Amendments to Approved Level II Site Plan – Ocean Gateway Addition

Project: Ocean Gateway Addition

To: Level II Site Plan Staff

JOHNSON & JORDAN
MECHANICAL CONTRACTORS
 18 MUSSEY ROAD
 SCARBOROUGH, ME 04074
 TEL: (207) 883-8345

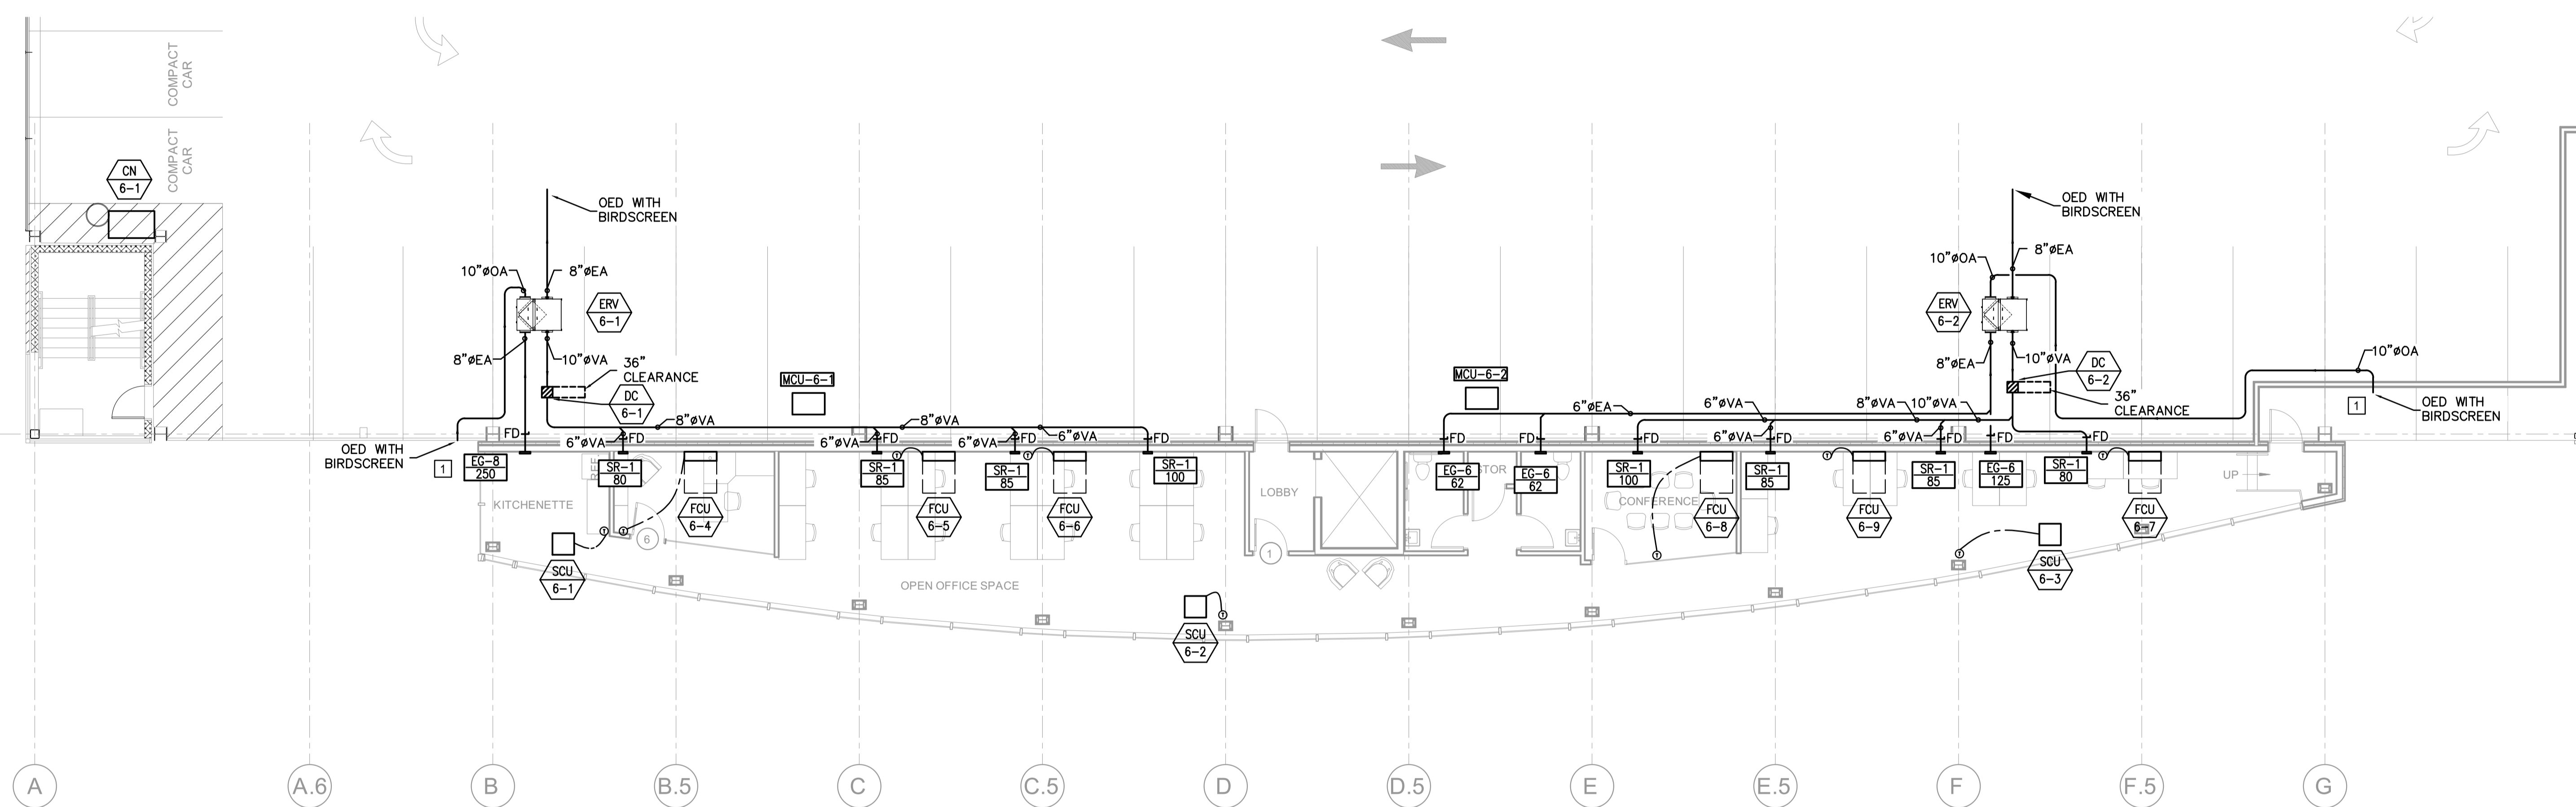
We have switched from rooftop mechanical units to wall mounted units at each floor. These units will be mounted on demising wall between addition and garage, and will not impact any of the parking spaces within the garage.

**1 | GROUND FLOOR PLAN**  
1/8" = 1'-0"

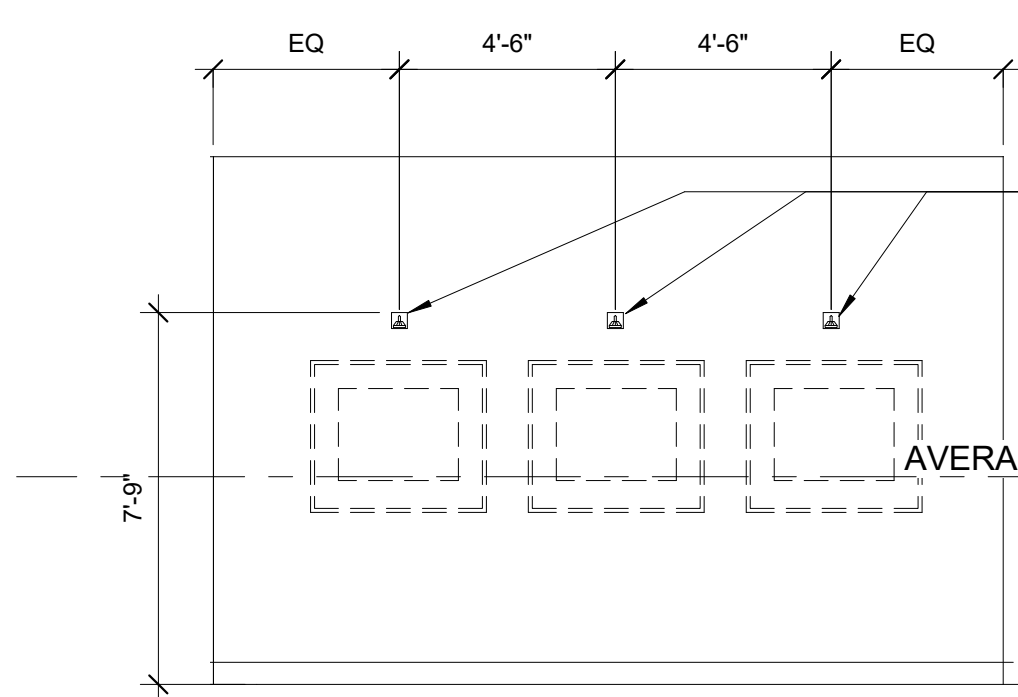
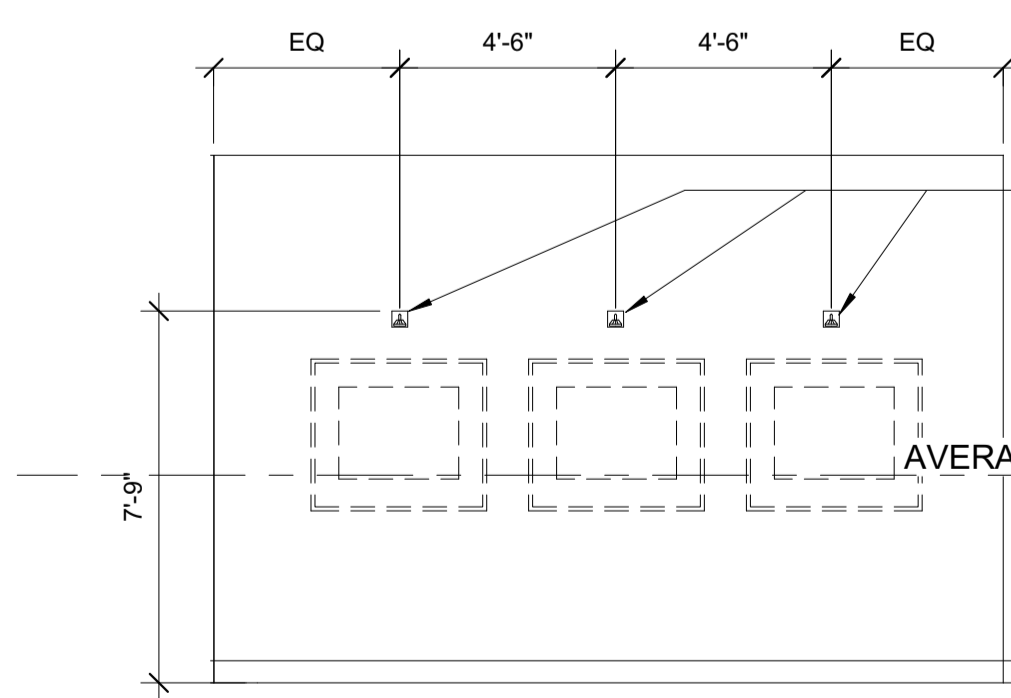
The approved site plan application included the design of the office addition to cantilever over the garage entrance on Fore St. This cantilever was to be wrapped in curtainwall, to match the rest of the addition. Due to structural impact and clearance requirements for drive lanes into existing garage, we have reduced the footprint of the office building by approx. 145 SF per floor (thus reducing the curtainwall) at the south west corner of the addition. We will no longer be cantilevering over the garage entrance, but instead will line up with the end wall of the existing retail space.

(These changes can be seen on floor plans A1.00 – A1.06 and building elevation on A2.01)

1 | ROOF PLAN
1/8" = 1'-0"

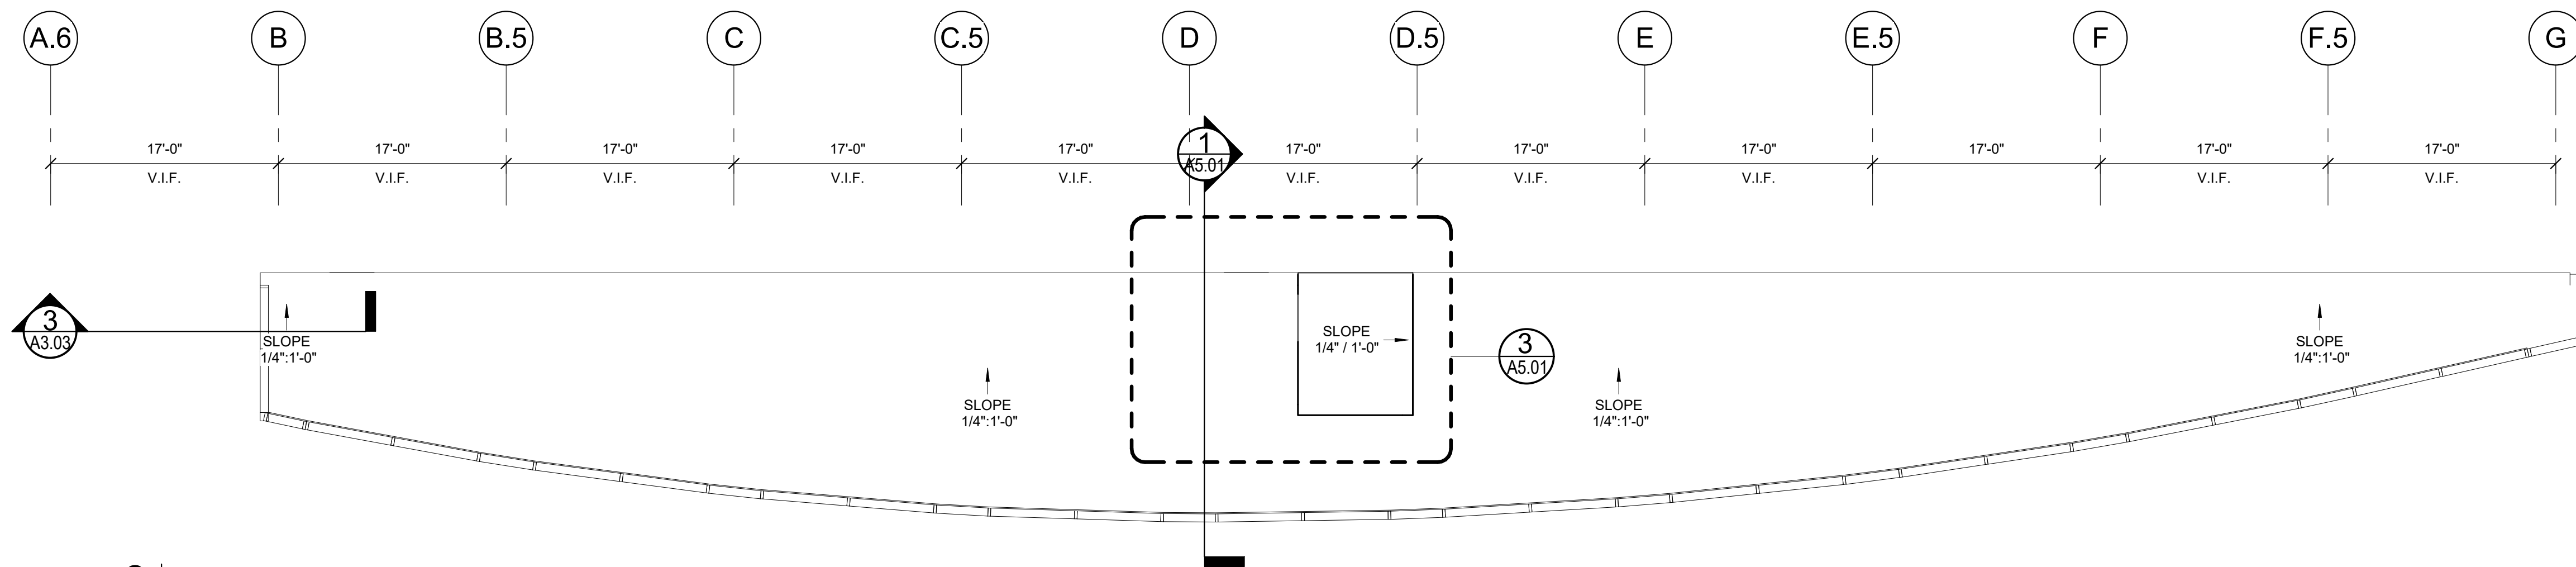
Due to the reduction in footprint of the addition, we have extended the length of the rated corridor in the garage, to maintain a rated corridor access from the addition to the existing exit stair of the garage.

(These changes can be seen on floor plans A1.01 – A1.06)

The original approved design included the end wall (southwest corner of addition) to be constructed of a metal stud wall to be wrapped in a metal panel system. We have changed this end wall, approx. 10'-0" in length, to a curtainwall system (to match front façade) to open up the space back to the city and create a stronger visual connection.

(These changes can be seen on floor plans A1.01-A1.06)
